Substantive response of the Local Highway Authority to a planning consultation received under The Development Management Order.

Planning Application Number: 22/0506/FUL

Application Address: Green Acres Aston Lane Aston Flamville Leicestershire LE10 3AA

Re-consultation. A detached double bay and cycle storage timber garage

Drg. No.
4537

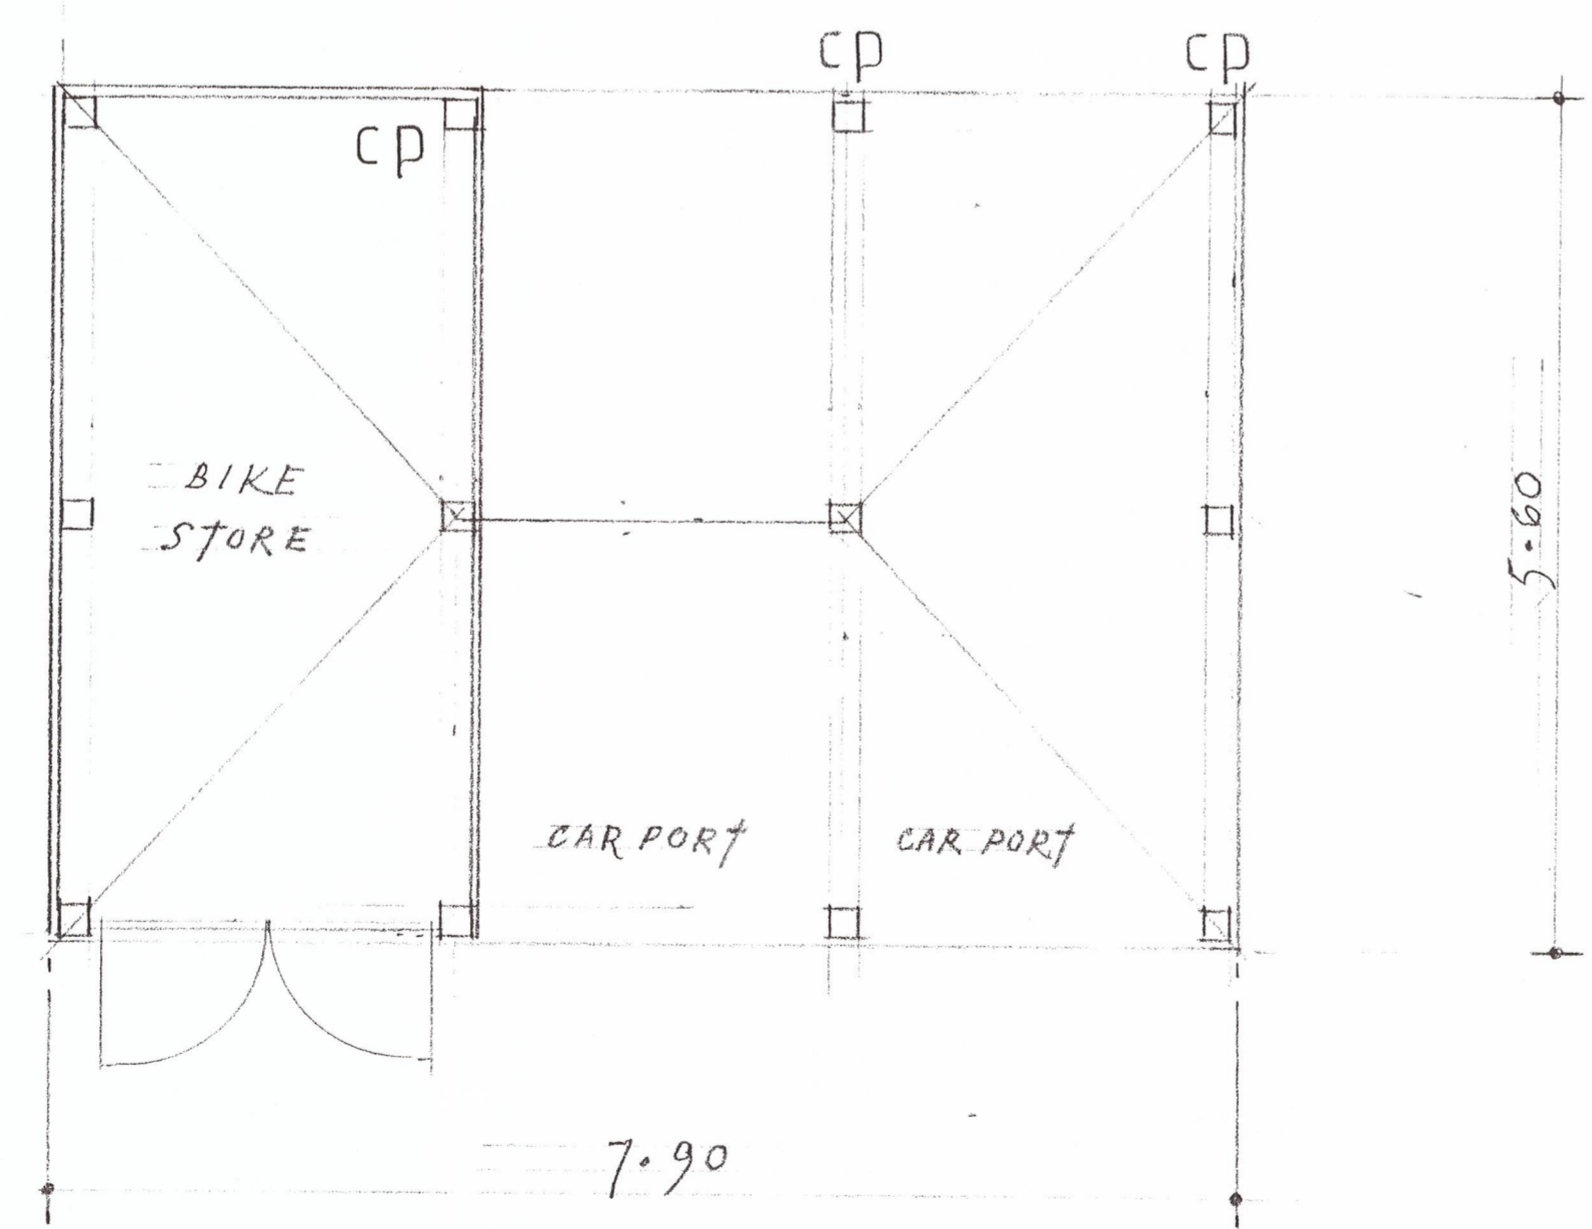
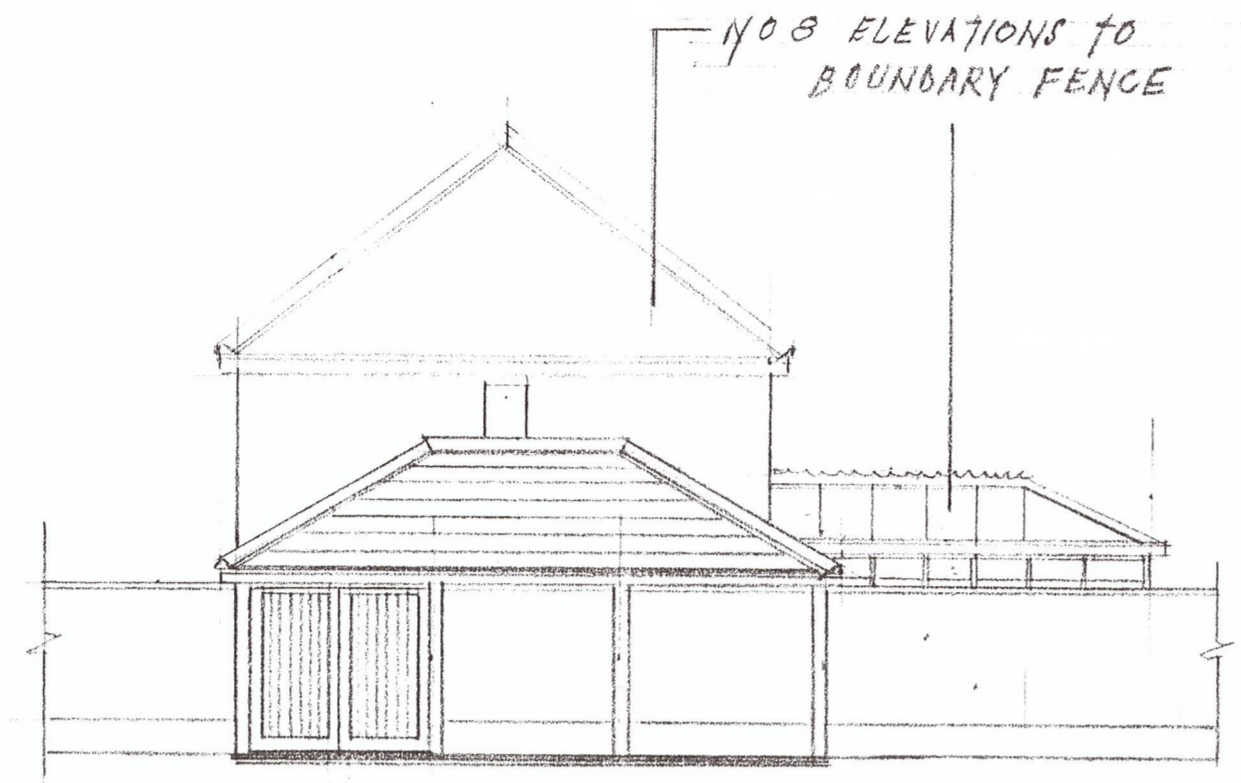
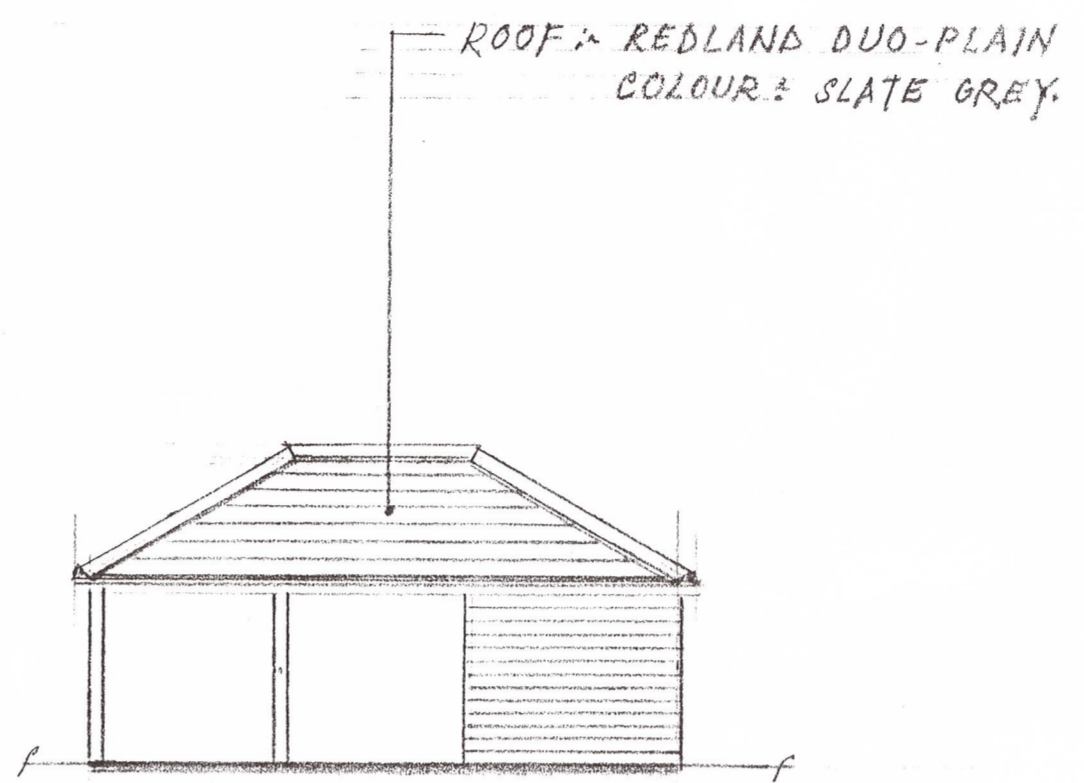
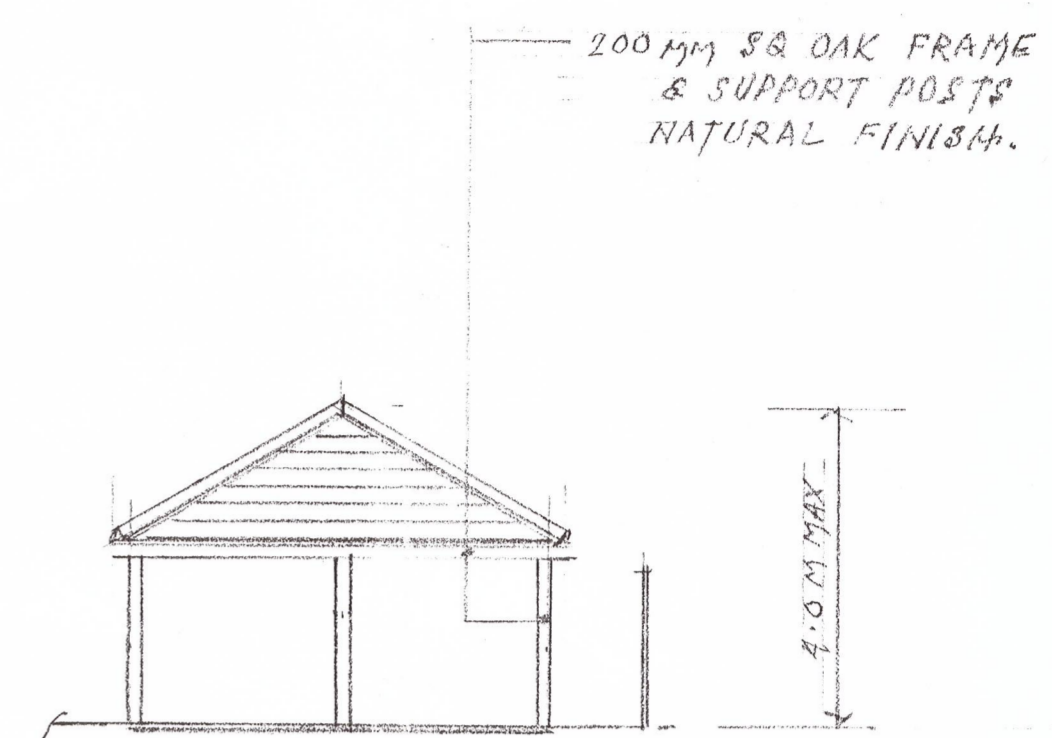
Whilst the double carport as demonstrated on plan 'Proposed Carport', drawing number 4537 is not in accordance with paragraph 3.200 of part 3 of the Leicestershire Highway Design Guide (LHDG), and the doors to the front of the cycle shed open into one of the customer car parking spaces, it should be noted that this also mirrors the previously approved scheme under 20/0473/FUL. As such the LHA do not feel they could resist the application in the event of an appeal.

Given the above, the LHA would not seek to resist the proposals.
